# CITY OF ALBUQUERQUE

**Re: Casa Feliz  
Erosion Sediment Control Plan  
Engineer's Stamp Date 2-8-16 (L19E073)**

Based upon the information provided in your submittal received 2-18-16 the above referenced plan is approved to be included in the SWPPP and for ESC Permit for grading and Building Permit.

The plan cannot be approved for Work Order until the following comments are addressed:

CITY OF ALBUQUERQUE PUBLIC WORKS DEPARTMENT ENGINEERING GROUP			
TITLE: CASA FELIZ TEMPORARY EROSION AND SEDIMENT CONTROL PLAN			
Design Review Committee	City Engineer Approval	Mo./Day/Yr.	Mo./Day/Yr.
City Project No.	Zone Map	Sheet	Of
621481	L-19-Z	1A	37

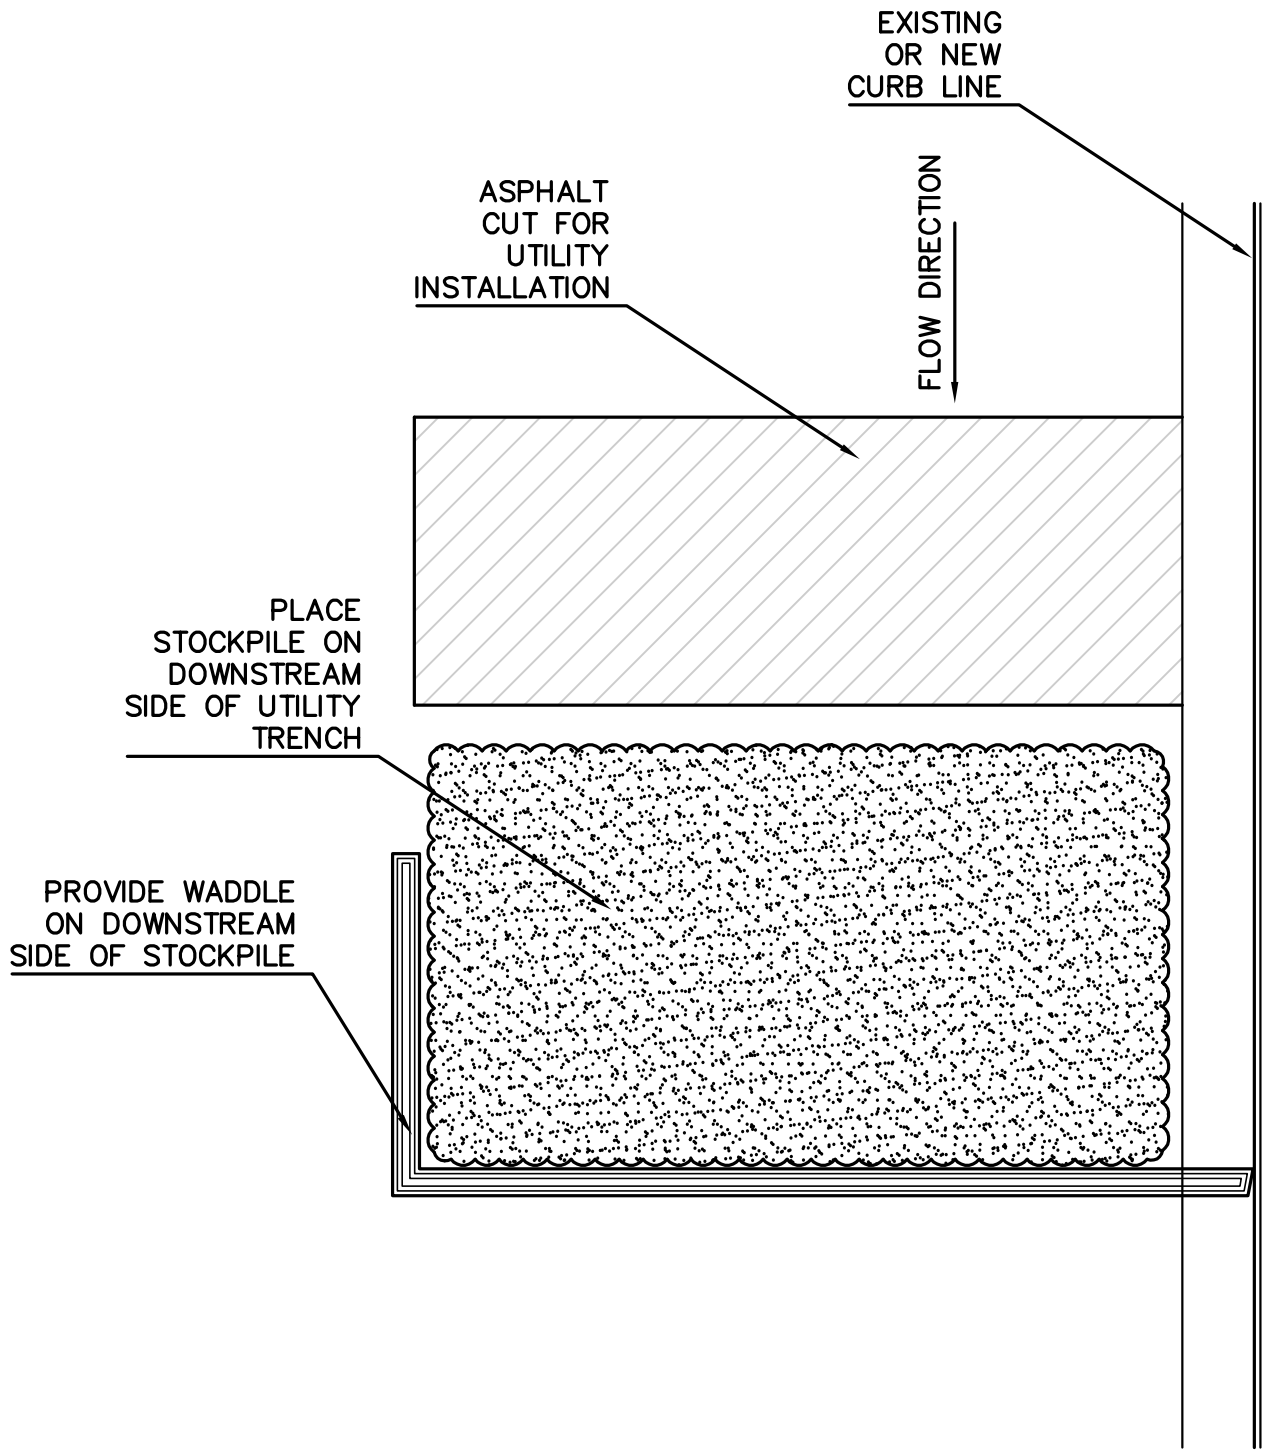
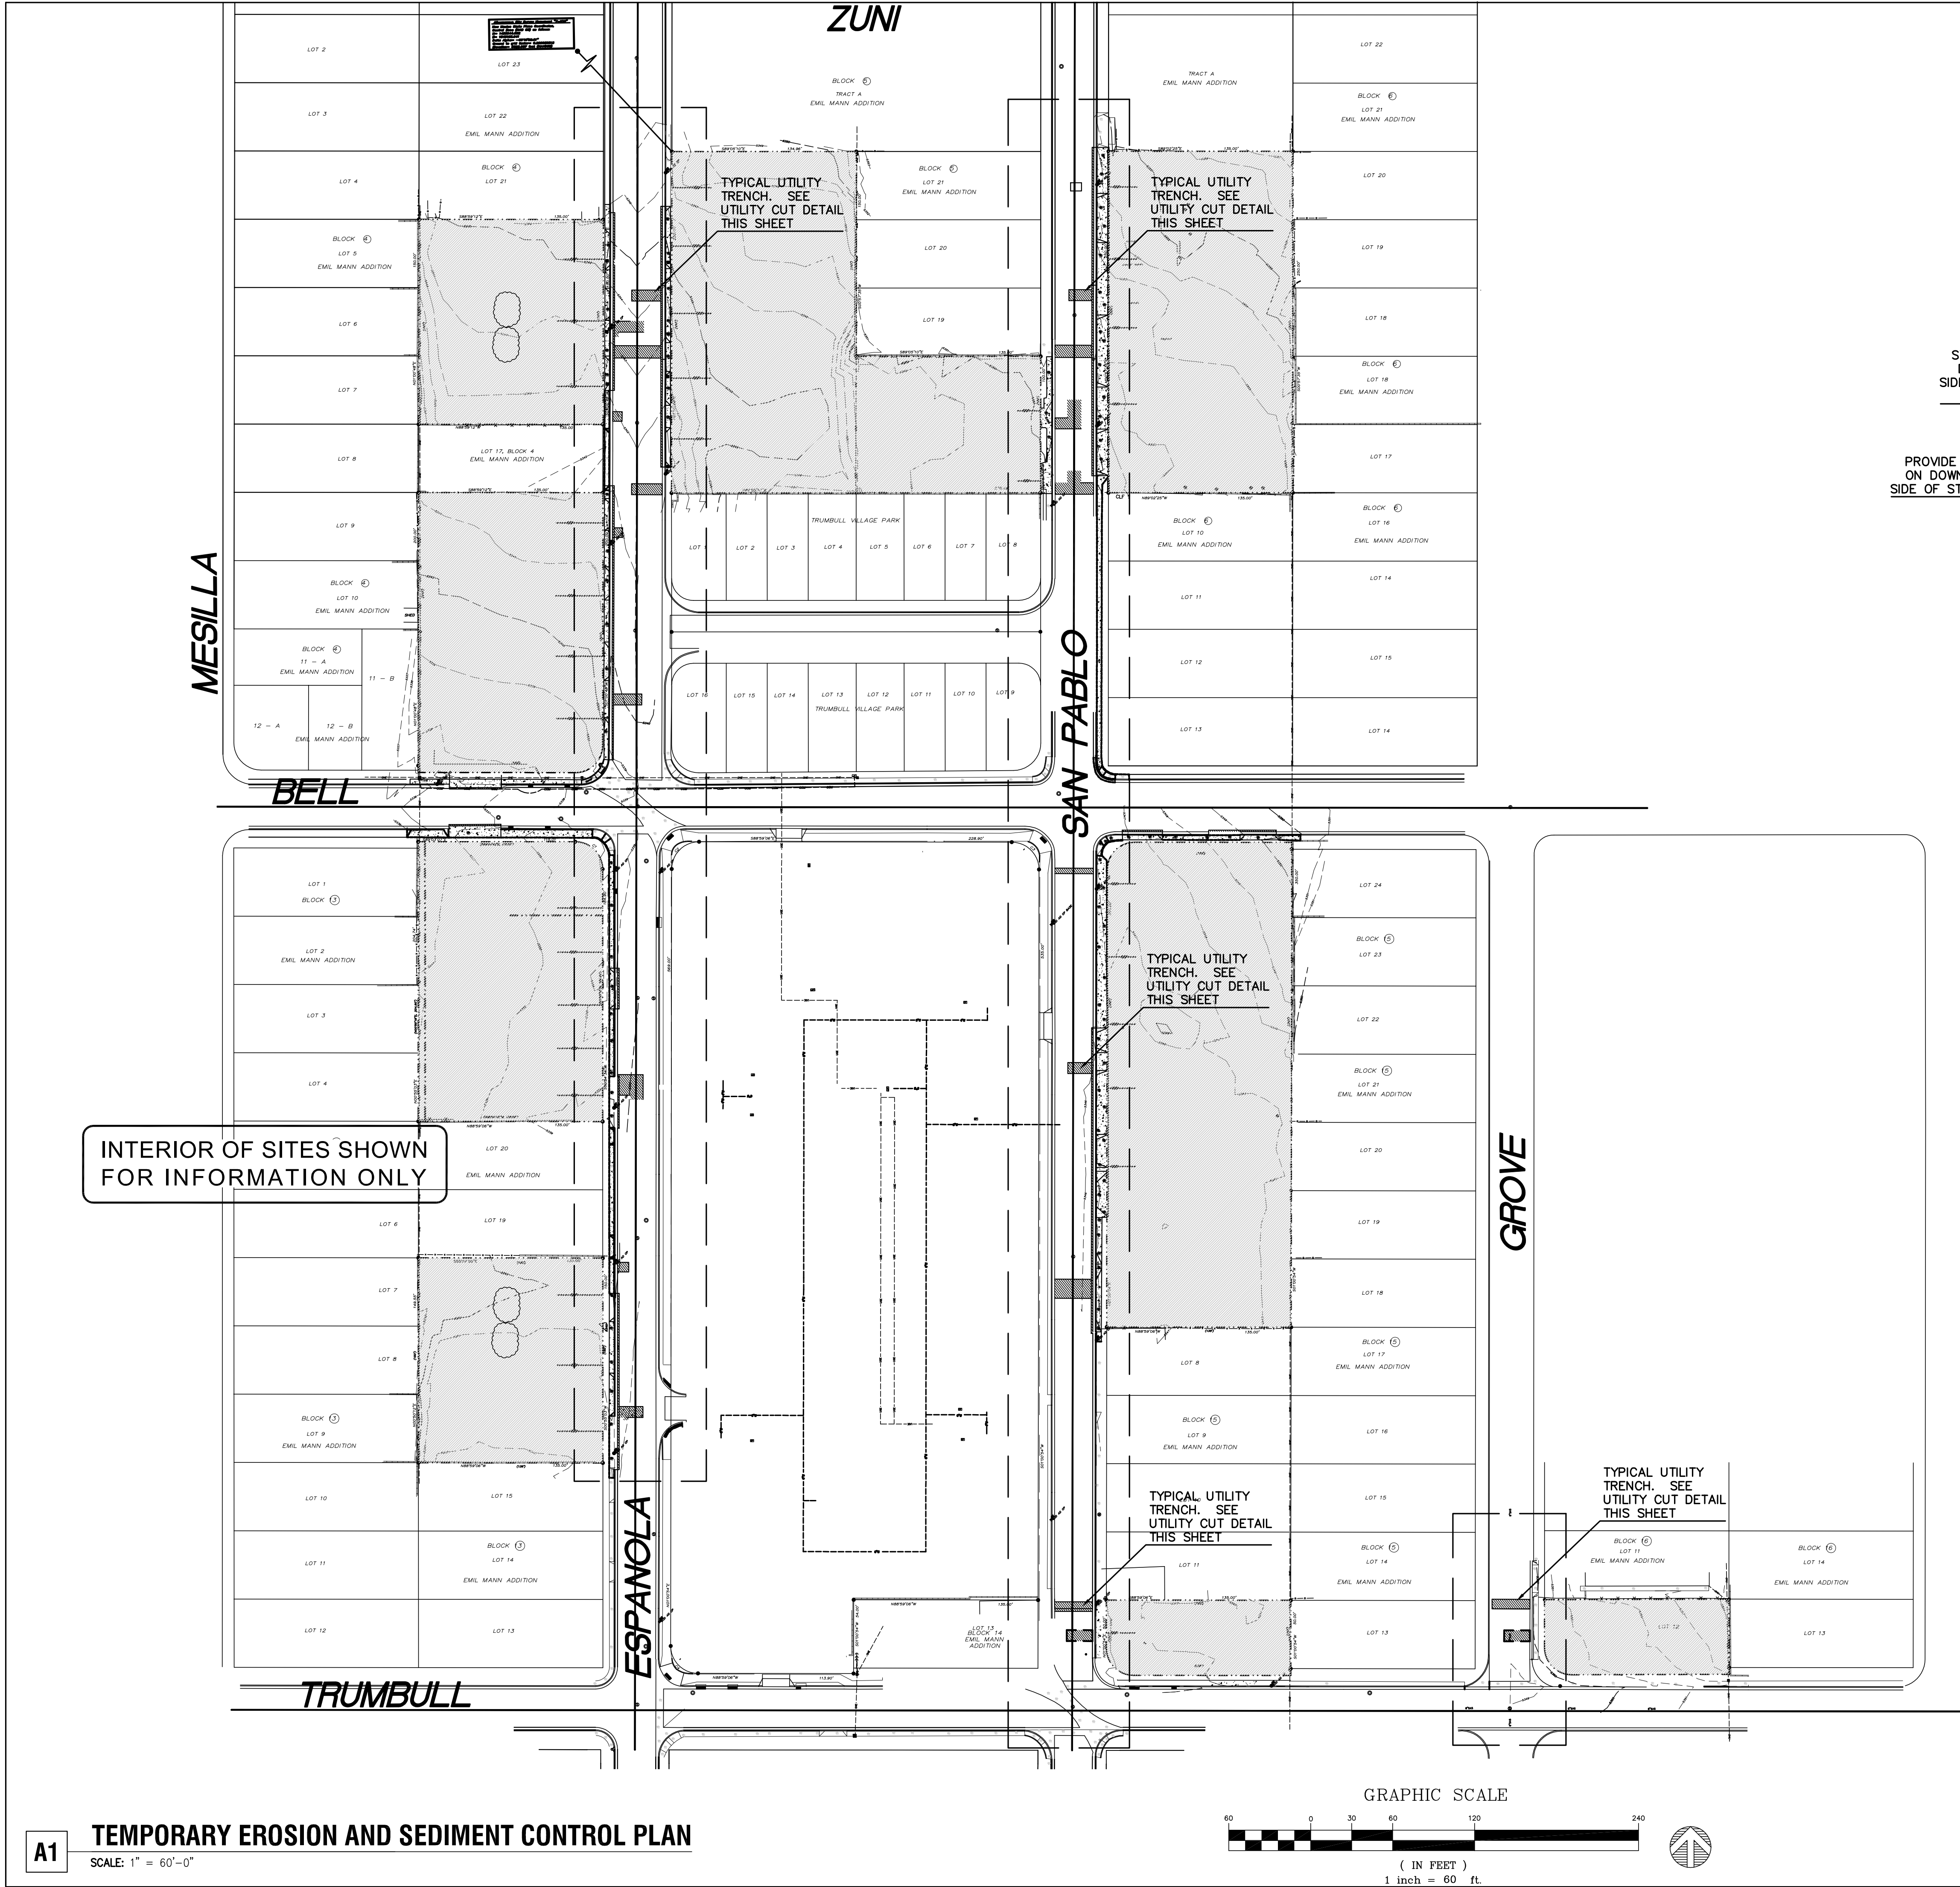
1. Add a legend item for the black rectangles in the street. They appear to be the utility cuts.
2. Since there are so many utility cuts on the Work Order, it may be beneficial to provide a detail of a "Typical Utility Cut" that includes a symbol for the dirt pile and a note that the dirt should be placed on the uphill side of the street cut and the area swept after the work is complete.
3. Please add a note or similar that when doing work in the City ROW (sidewalk, curb and gutter, drive pads, etc...) to avoid dirt from getting into the street. If dirt is present in the street, the street should be swept every few days or the same day if rain is eminent.
4. There is an inlet on Trumbull Ave. on the north side of the street east of San Pablo that will need inlet protection when the curb and gutter is getting replaced.
5. Show the inlets on Bell Ave. west of Espanola Street.
